**From:** Cruse & Associates <cruseandassoc@kvalley.com>  
**Sent:** Wednesday, January 16, 2013 1:14 PM  
**To:** Christina Wollman  
**Cc:** Jeff Watson  
**Subject:** Re: daugherty bla

**From:** Christina Wollman  
**Sent:** Monday, January 07, 2013 10:49 AM  
**To:** Cruse & Associates ([cruseandassoc@kvalley.com](mailto:cruseandassoc@kvalley.com))  
**Subject:** daugherty bla

It looks like this BLA is to correct an encroachment onto the Umland property. Is it possible for you to show the actual driveway location on the "proposed" drawing?

PROPOSED BOUNDARY

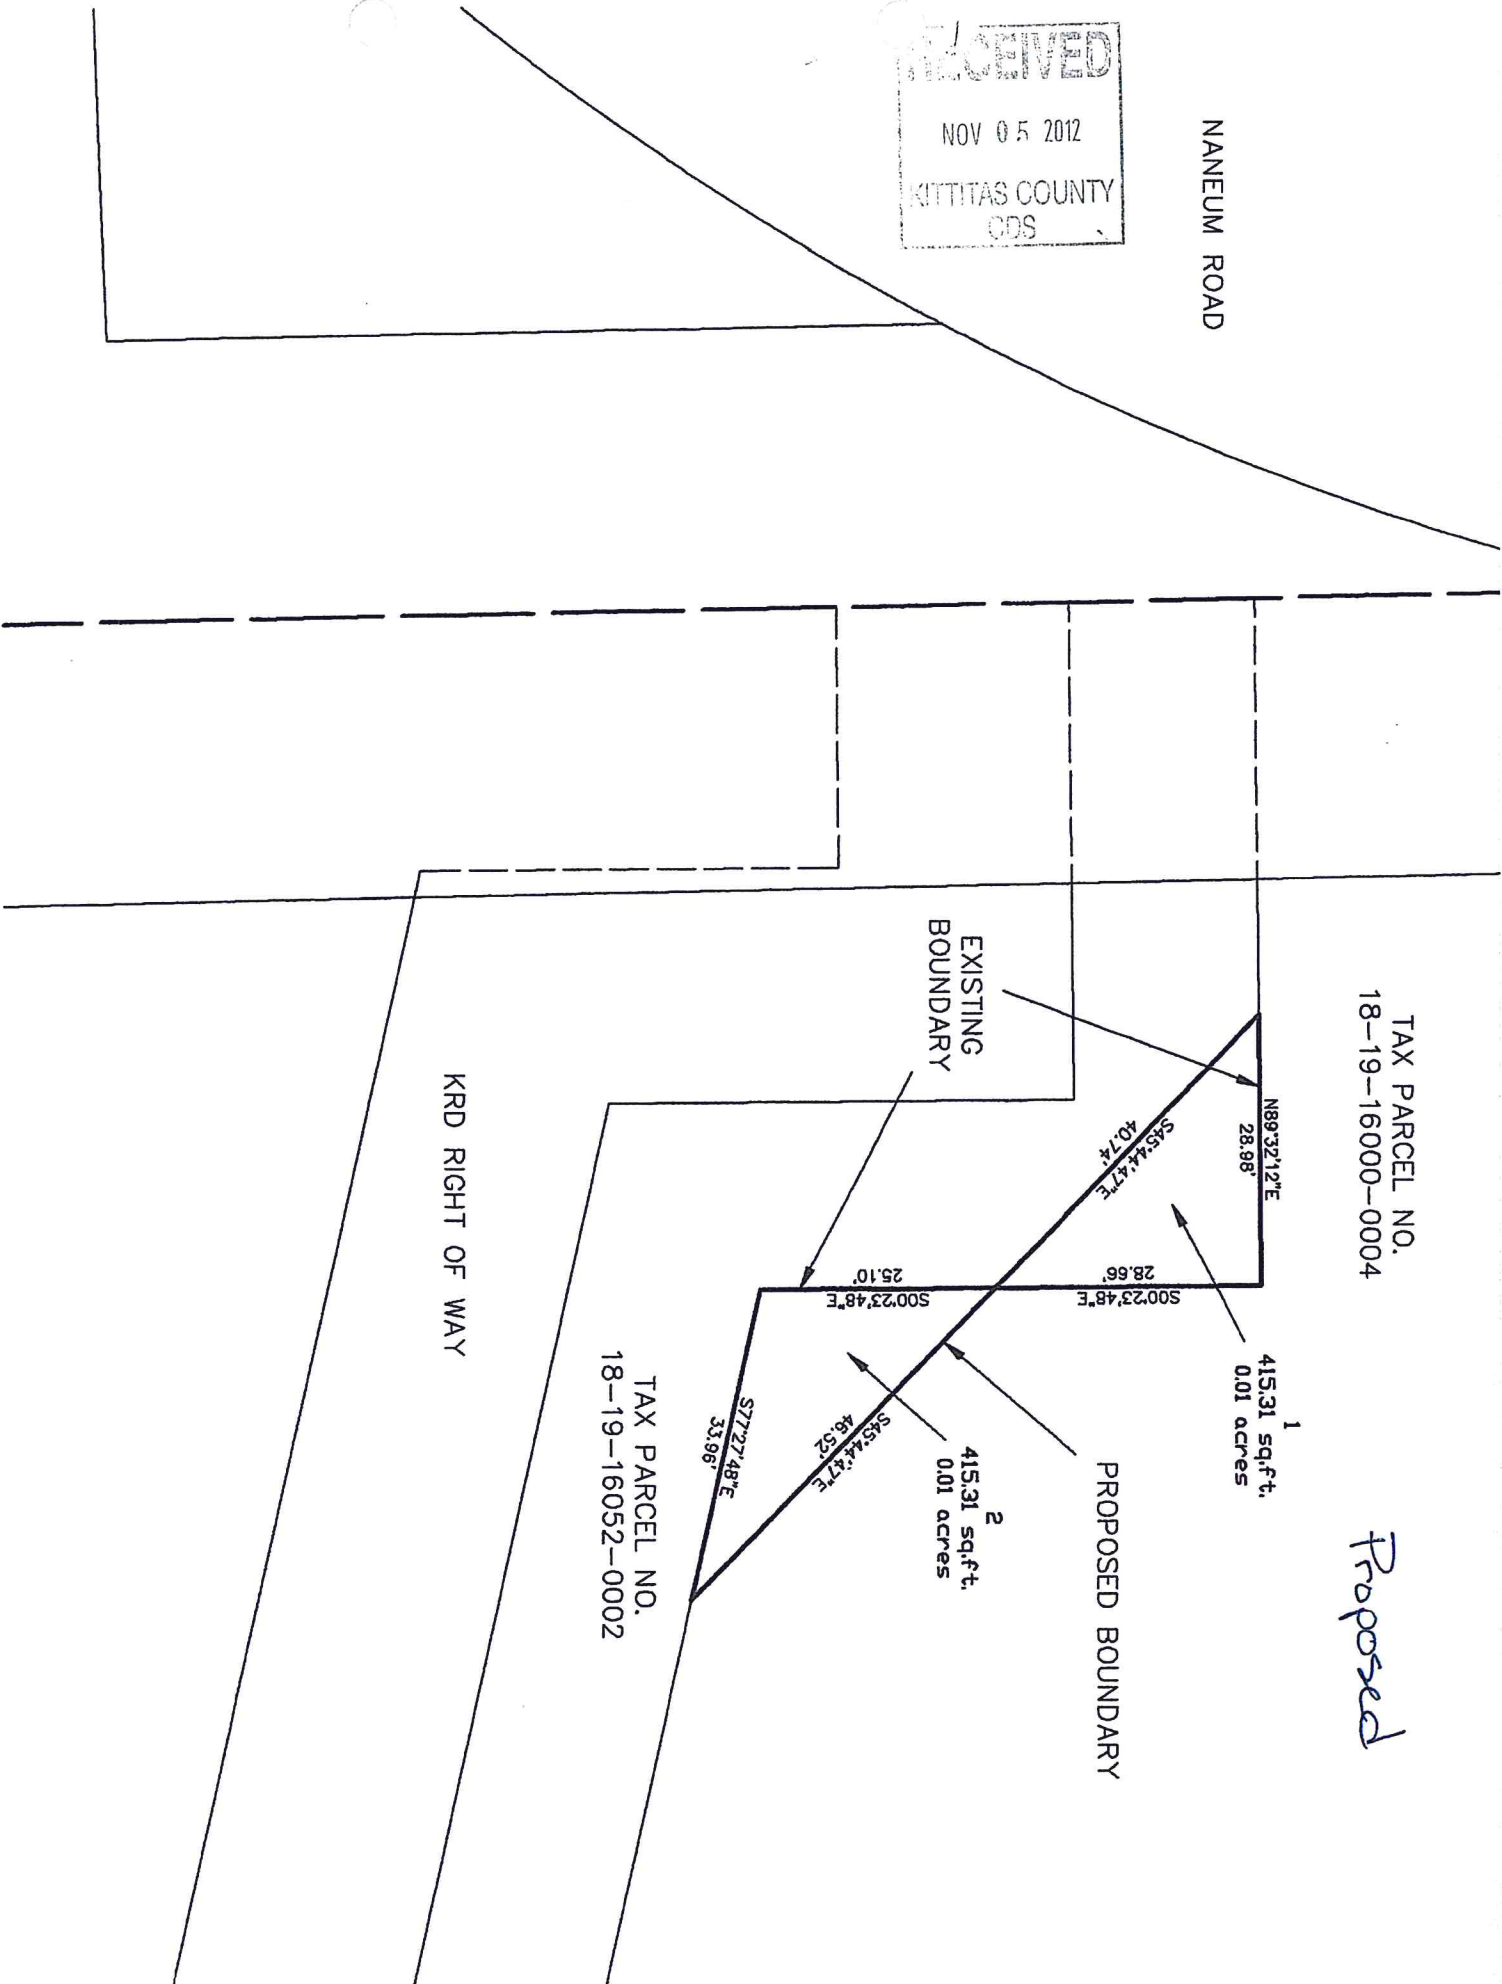
What is the distance between the KRD NE corner and the proposed boundary (see red line on attachment)? It look like it's only about 10'. I will not be able to approve this BLA with that narrow of width without an easement.
